Our Ref: EP/108/19/HH
Your Ref:

Town & Country Planning Act 1990 (as amended)
Town & Country Planning (Development Management Procedure) (England) Order 2015
Application for Planning Permission for Works or Extension to a Dwelling

Development Two storey front, two storey side and two storey rear extension and additional parking bay to garage
Location Caprice 17 Tamarisk Way East Preston

Block Plan 1:500

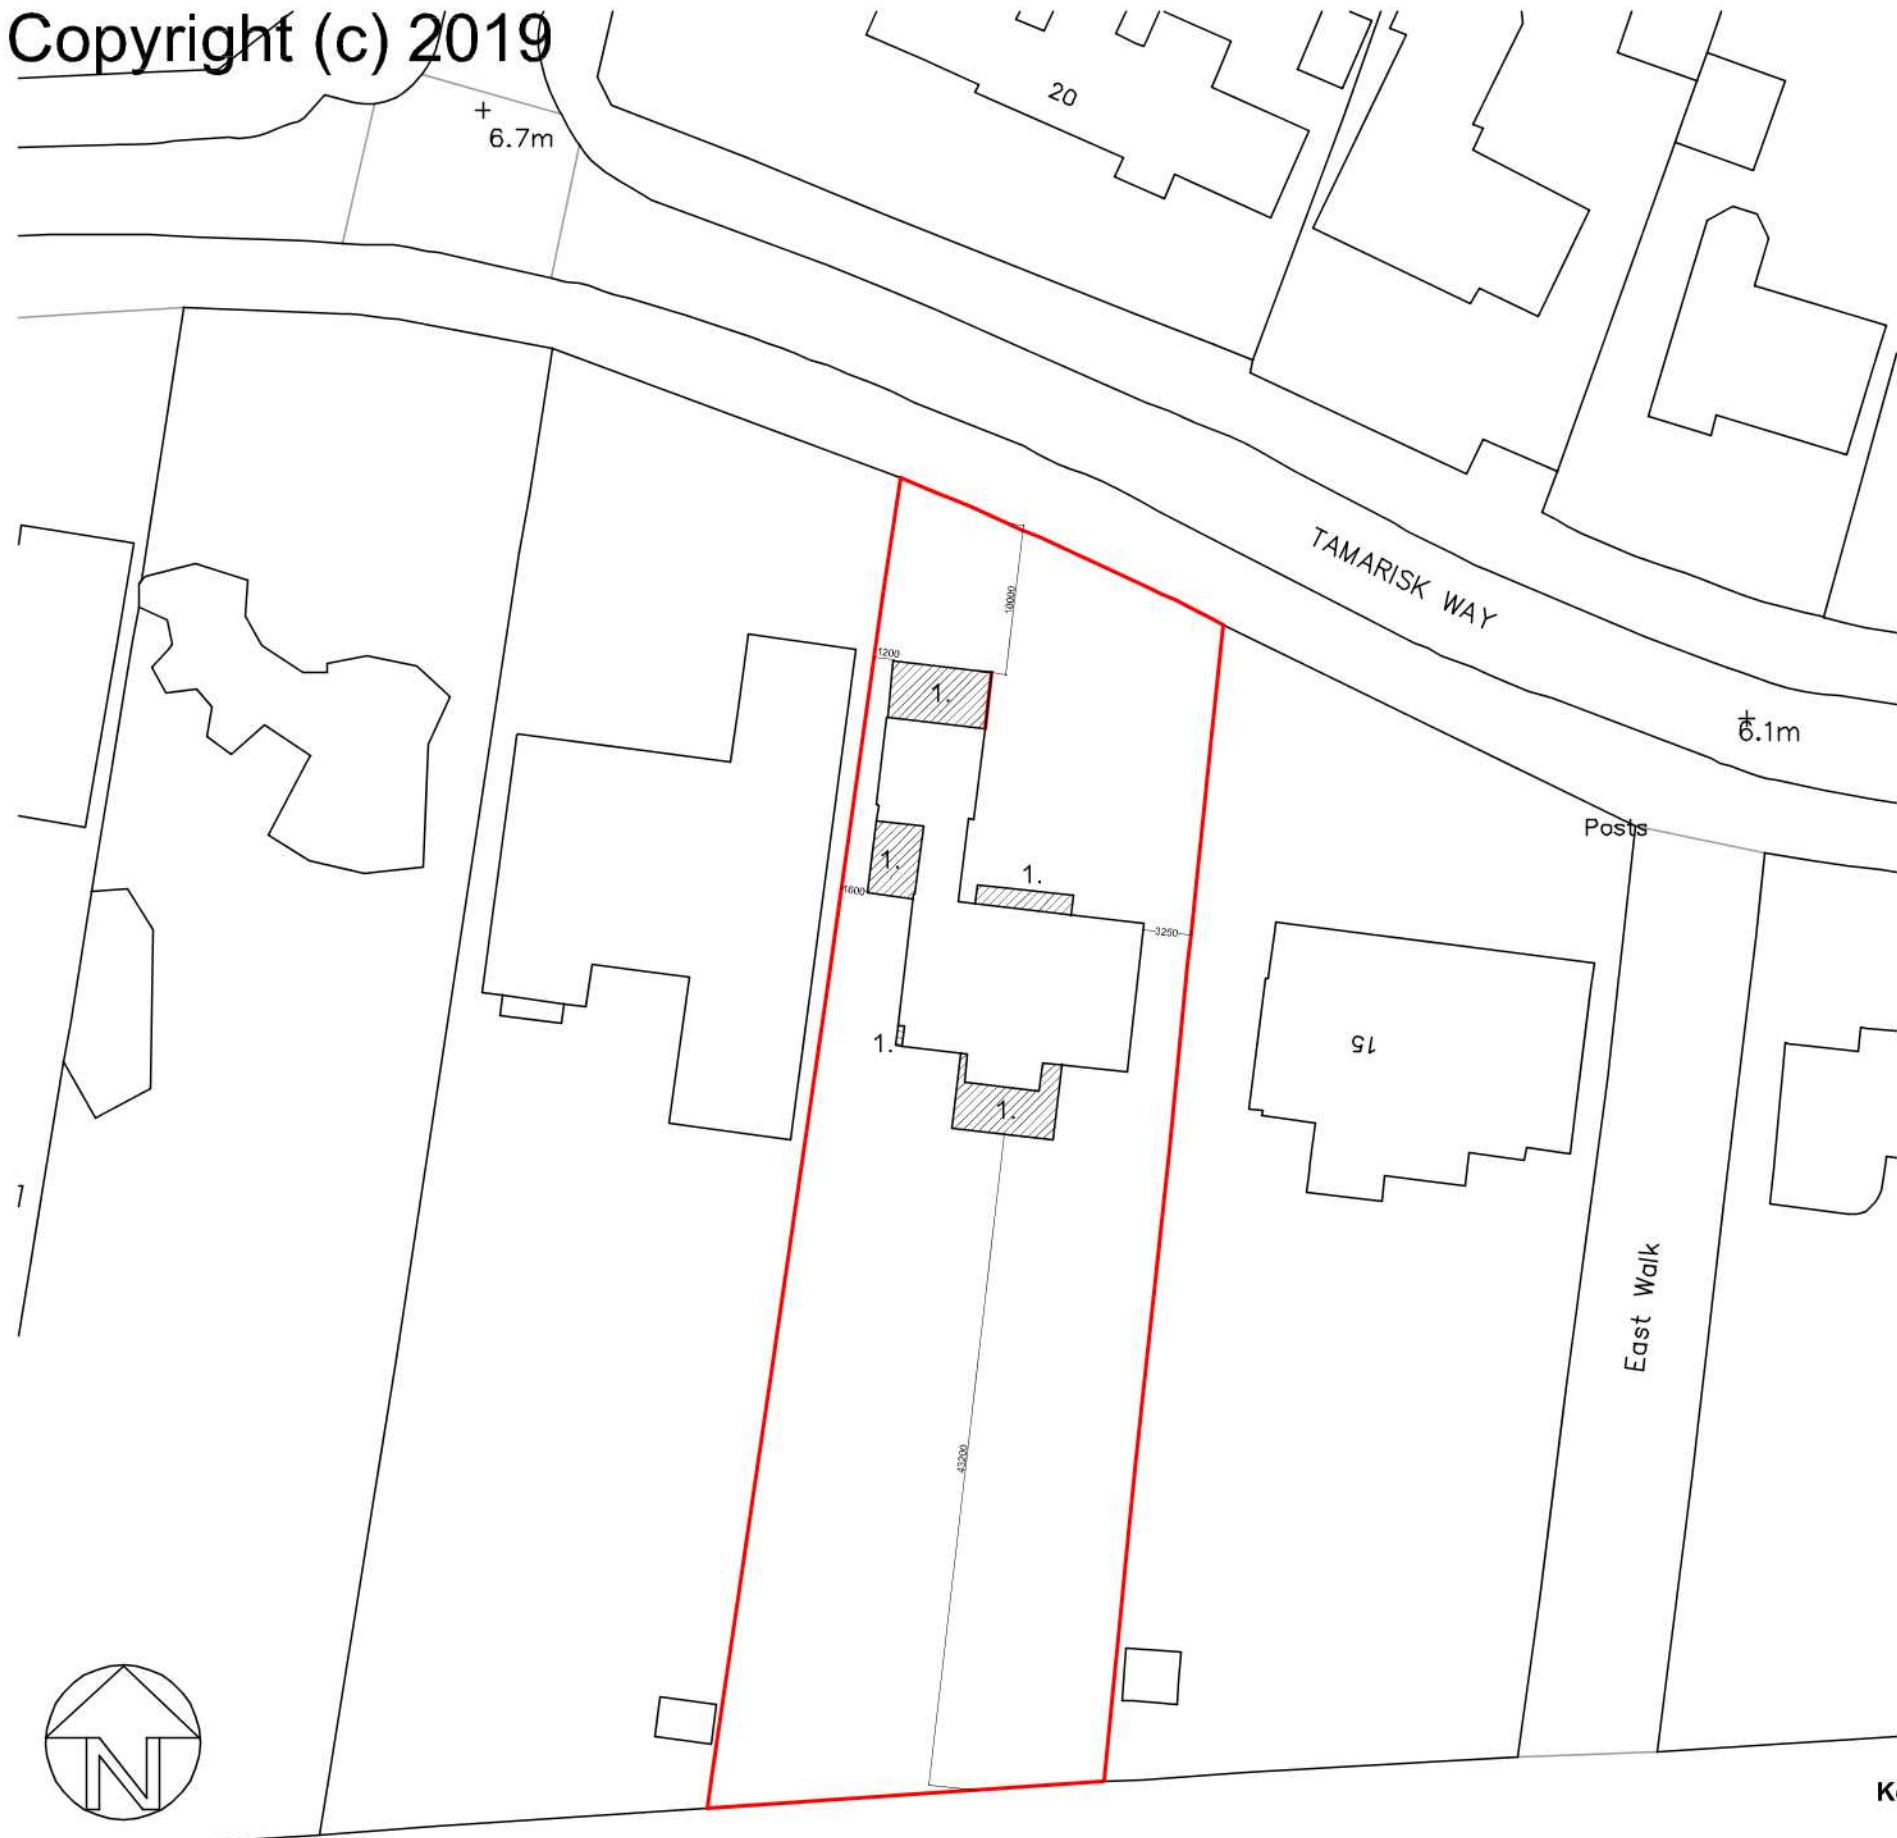
Block Plan

You are required to include dimensions on the block plan from the proposed extensions to all site boundaries.
